Re: Certification Submittal for Final Building Certificate of Occupancy for
Pathway Inc. Parking Lot, [J17 / D27]
622 Truman NE
Engineer's Stamp Dated 06/21/04

Re: Pathway Inc. Parking Lot, 622 Truman St NE, Traffic Circulation Layout
Engineer's Stamp dated 4-15-04 (J17/D27)

**Re: Pathway Inc. Parking Lot, 622 Truman St NE, Traffic Circulation Layout
Engineer's Stamp dated 3-23-04 (J17/D27)**

**TRAFFIC CIRCULATION LAYOUT
APPROVED**

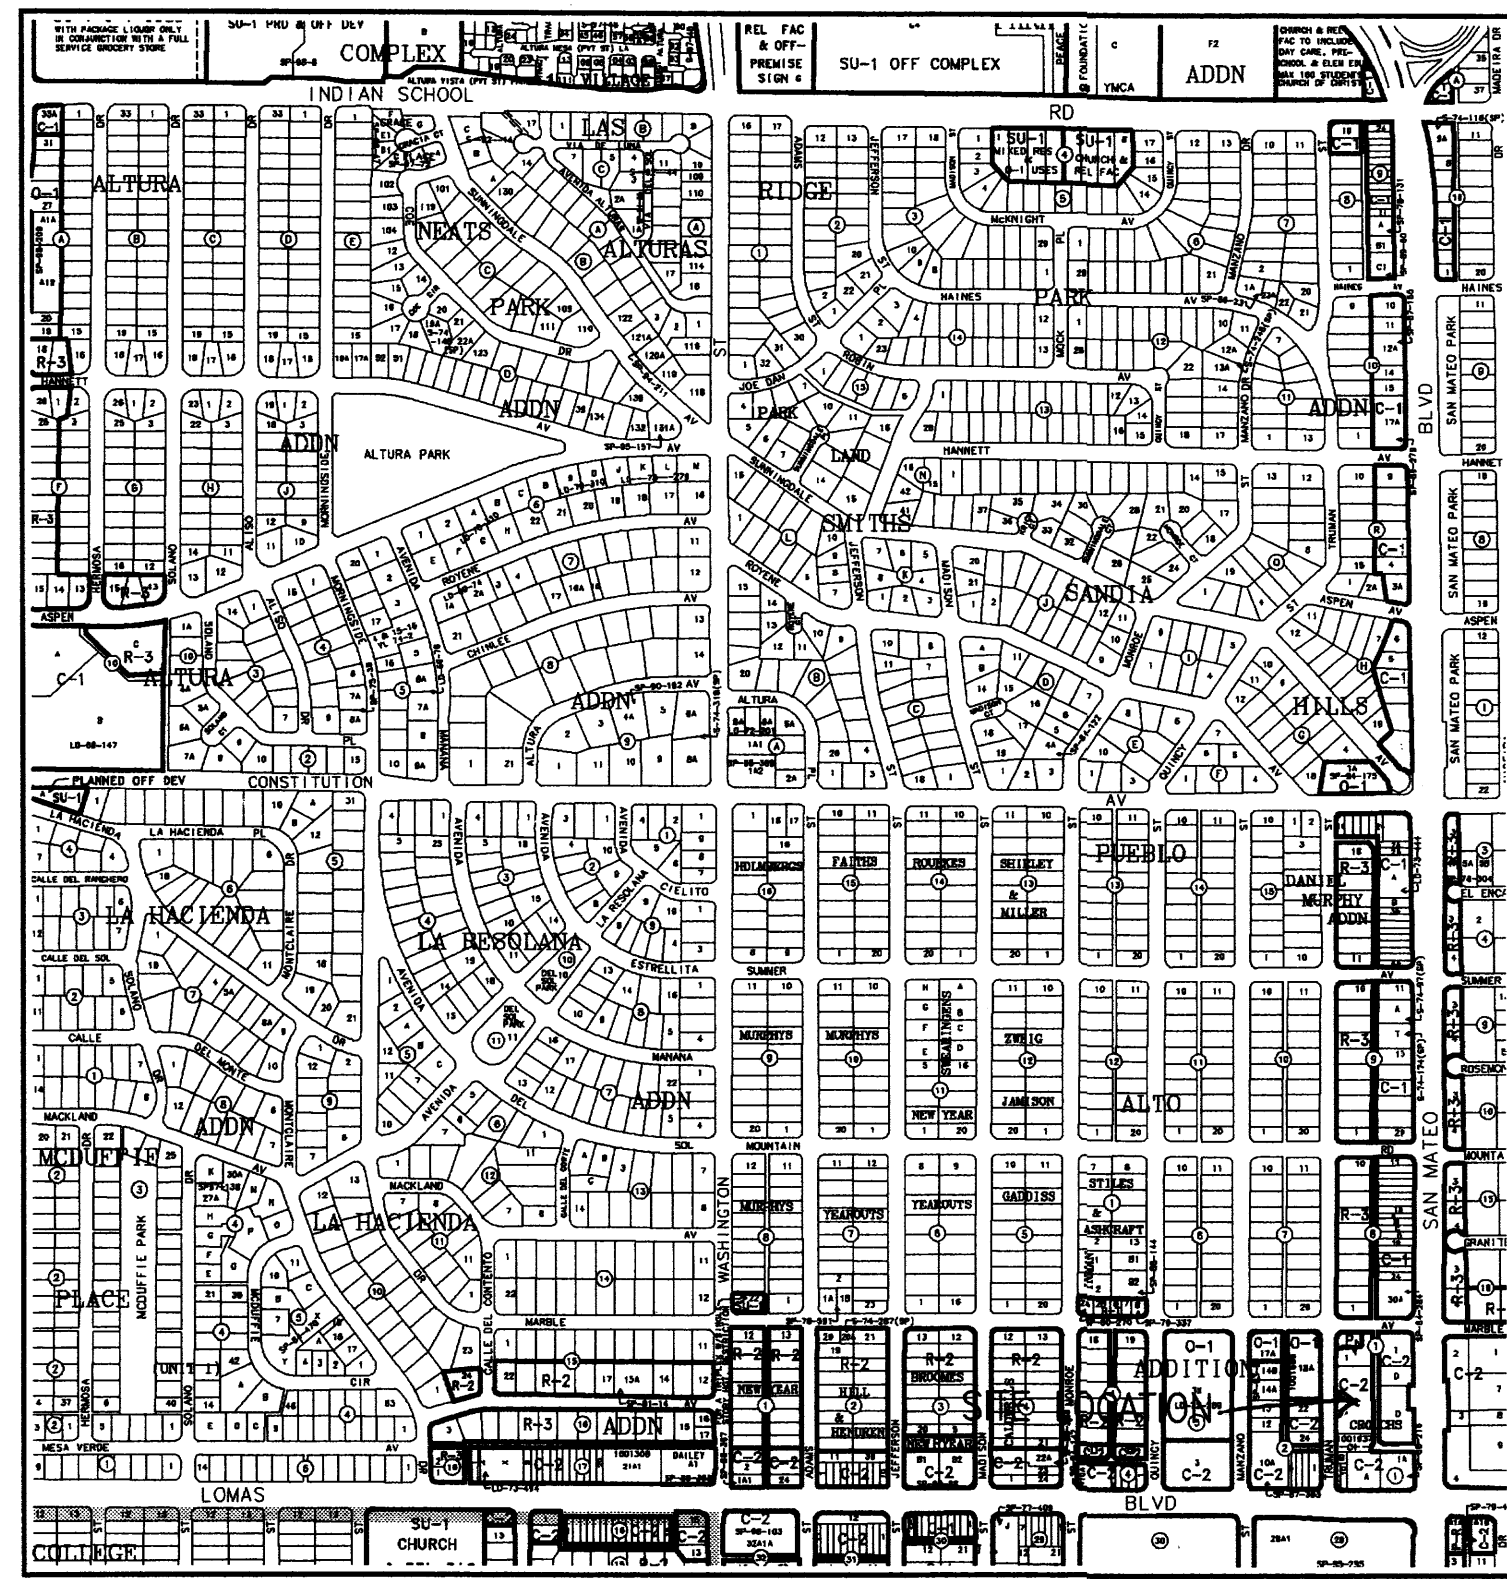
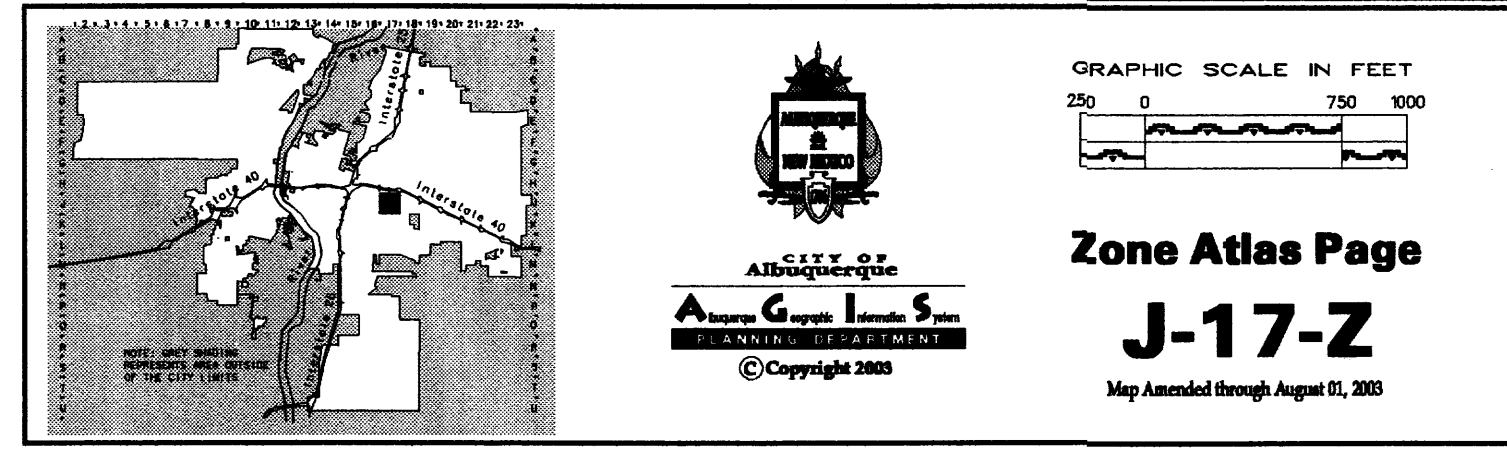
1. List radii for all curves shown.
2. Please include 2 copies of the traffic circulation layout at the next submittal.
3. List the number of handicapped accessible parking spaces required, and show the location of these spaces.
4. Parking stalls at a 45-degree angle require a 34.3 foot vertical length for two lot width, and a 20.14 foot vertical length for one lot width. Please refer to the Development Process Manual for details.
5. Please show directional striping for one-way circulation.
6. Are there any exits to the alley?
7. The proposed parking spaces currently block the entrance.
